**Re: Planning Ref 23/01233/OUT OS Parcel 4347 East of Pipal Cottage, Oxford Road, Kidlington.****The Proposal**

Outline application (with all matters except access reserved for future consideration) for the demolition of existing buildings and the erection of up to 800 dwellings (Class C3); a two form entry primary school; a local centre (comprising convenience retailing (not less than 350sqm and up to 500sqm (Class E(a))), business uses (Class E(g)(ii)) and/or financial and professional uses (Class E(c)) up to 500sqm, caf? Or restaurant use (Class E(b)) up to 200sqm; community building (Class E and F2); car and cycle parking); associated play areas, allotments, public open green space and landscaping; new vehicular, pedestrian and cycle access points; internal roads, paths and communal parking infrastructure; associated works, infrastructure (including Sustainable Urban Drainage, services and utilities) and ancillary development. Works to the Oxford Road in the vicinity of the site to include, pedestrian and cycle infrastructure, drainage, bus stops, landscaping and ancillary development

**Response**

DRAWN	CHECKED	APPROVED
PH	JDW	JDW
PROJECT No:	SCALE @ A1:	DATE:
ITB16565	1:500	13.01.23
DRAWING No:	ITB16565 - SK - 067	
		REV: H

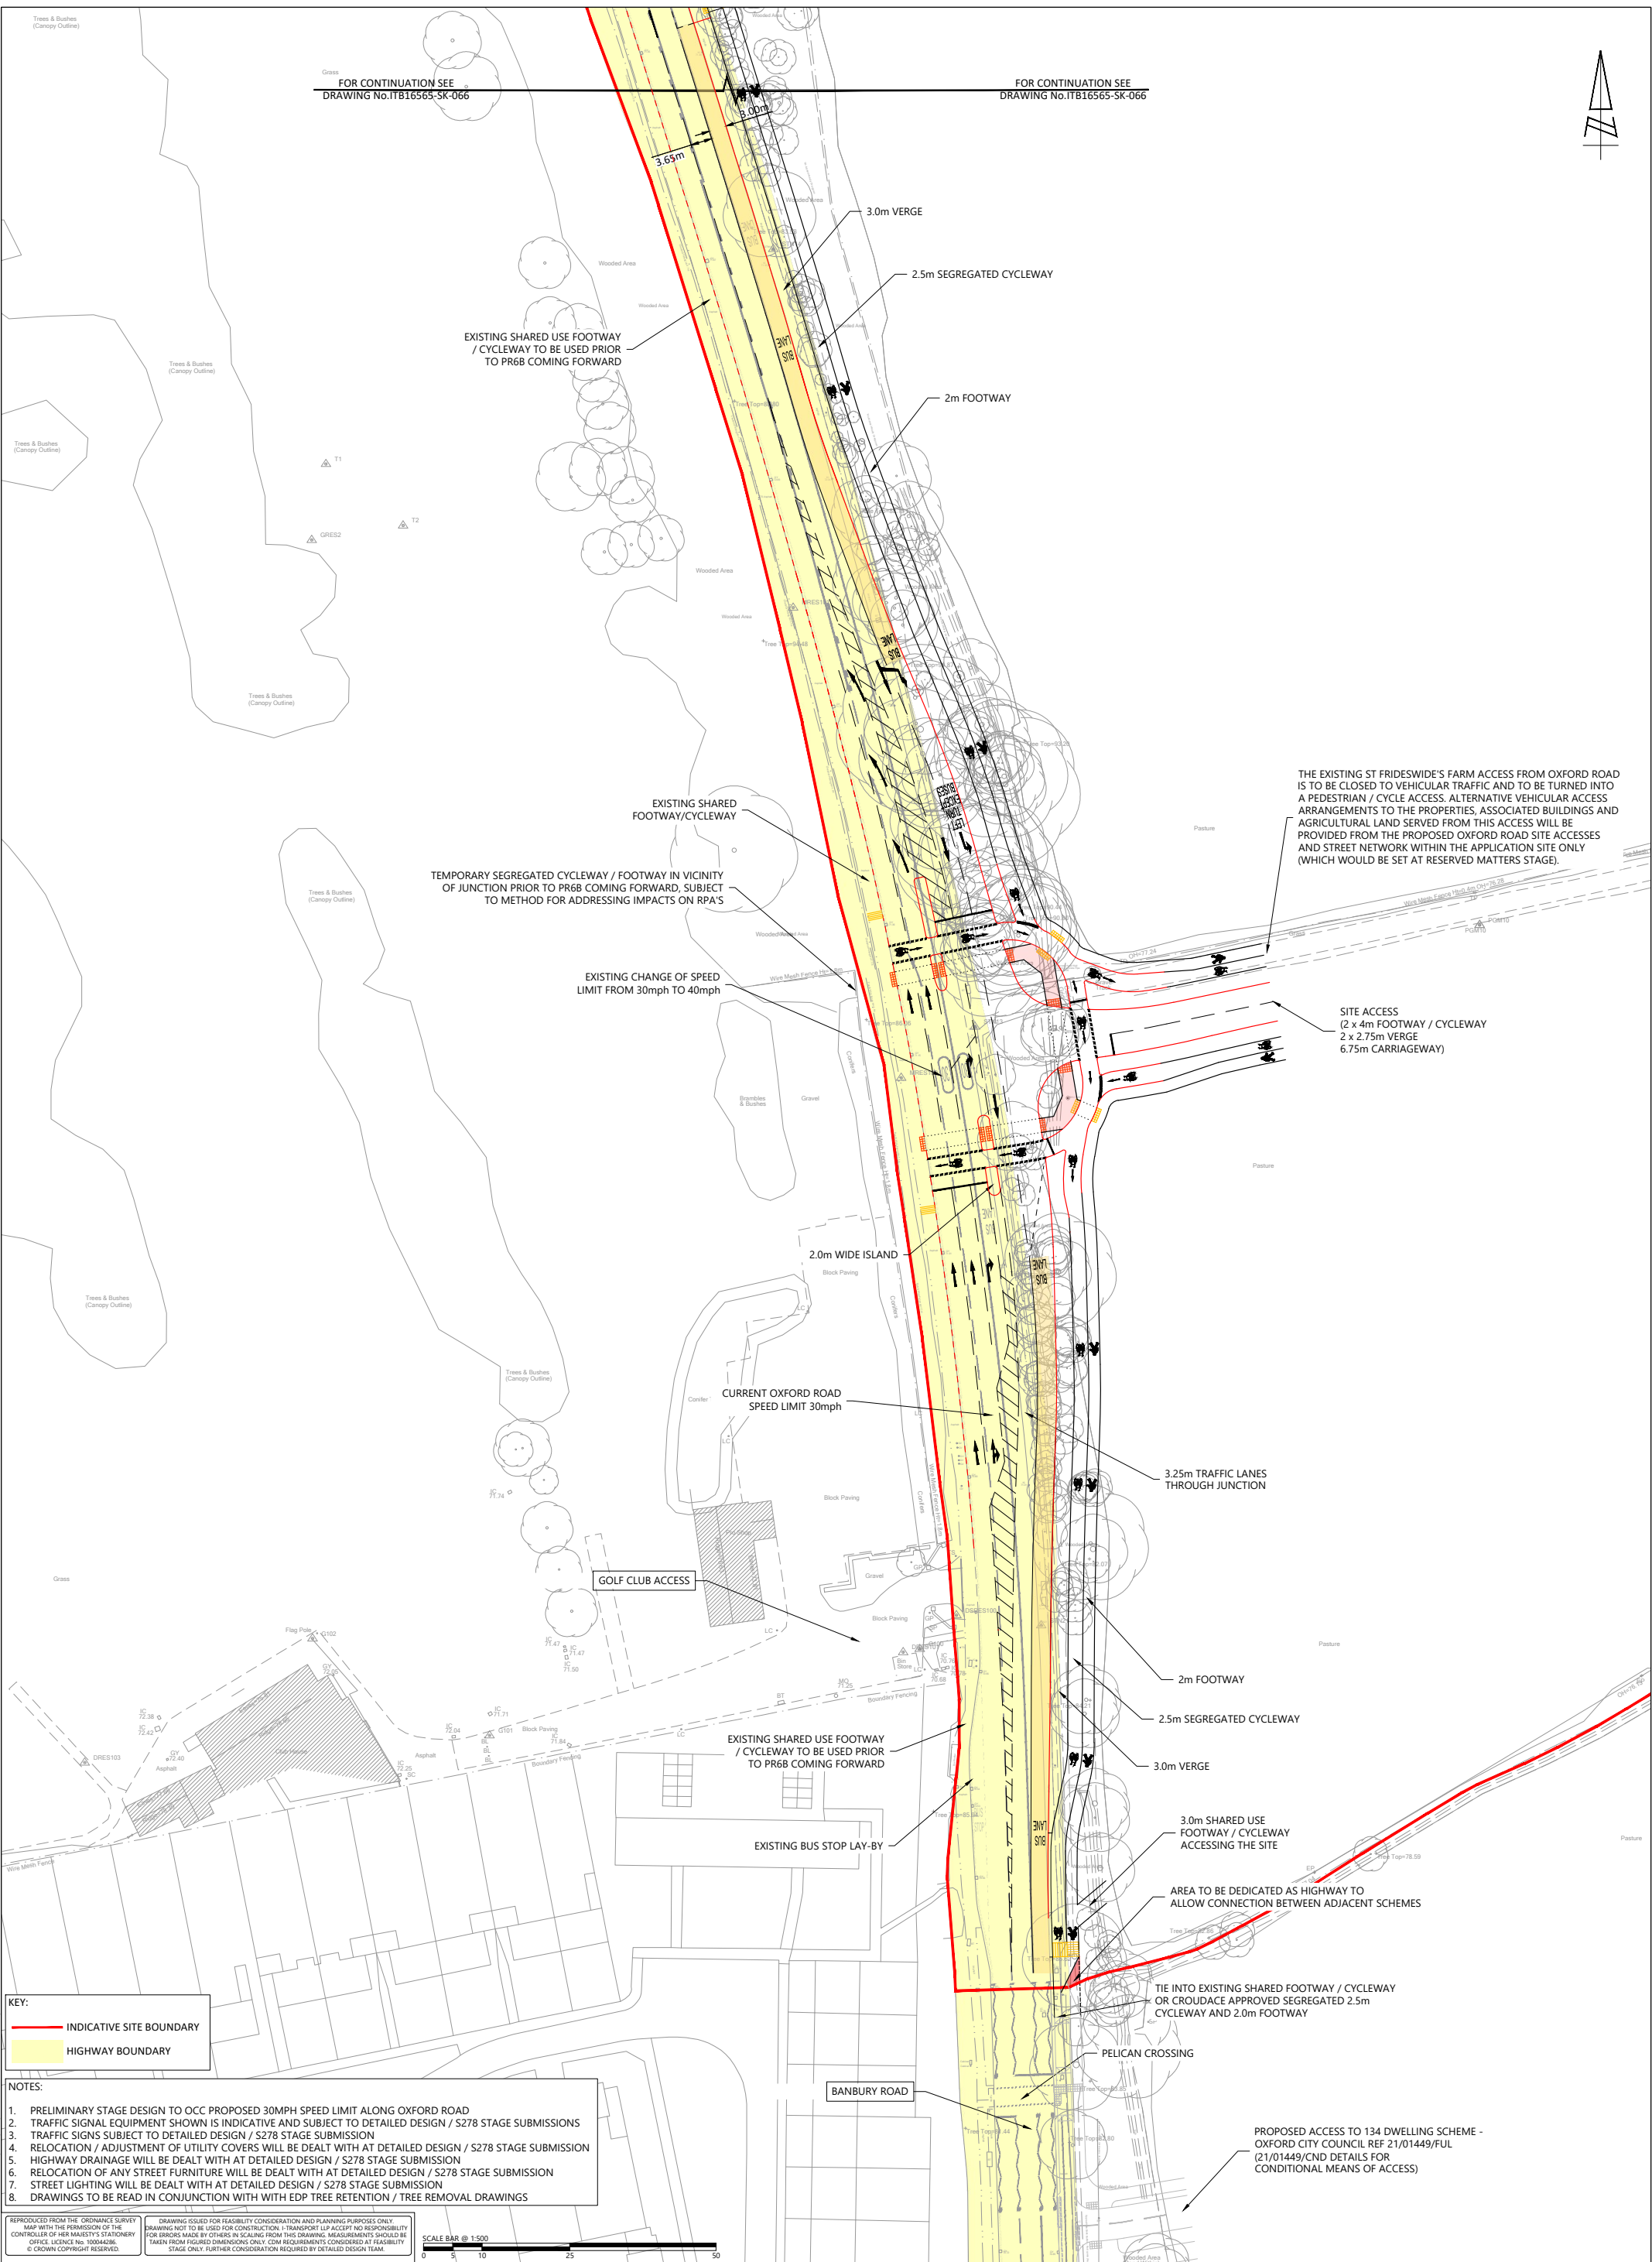
1. Vehicles that are lawfully using the bridleway must give way to any members of the public walking, riding or cycling along the bridleway. It is unclear on the map in the Planning Statement how the bridlepath will proceed from the Play/Games Area to the toucan crossing on the main road. If this is to be along or across drives through the development then the relevant right of way signage will be needed, and consideration of the surface needed, as tarmac is not a suitable surface for bridleways, two leaflets may be found in the Structures and Surfacing area at [Access and bridleways advice | The British Horse Society \(bhs.org.uk\)](#)
2. There is no mention as to how the bridal path will run through the Games/Play area as to whether there will be signage, or a separated route.

3. This could have been an excellent opportunity to expand the provision for Equestrian users, as has been done for pedestrians and cyclists, by providing access to Cutteslow Park.
4. Although a toucan crossing is mentioned there are no details as to the locating of the signal controls for equestrian users. The BHS has recommendations for the distance and type of controls best used at [Access and bridleways advice | The British Horse Society \(bhs.org.uk\)](#)
5. The definitive route of the bridleway must be maintained along the line recorded on the Oxfordshire Definitive Map (<https://www.oxfordshire.gov.uk/residents/environment-and-planning/countryside/countryside-access/public-rights-way/public-rights-way-online>).
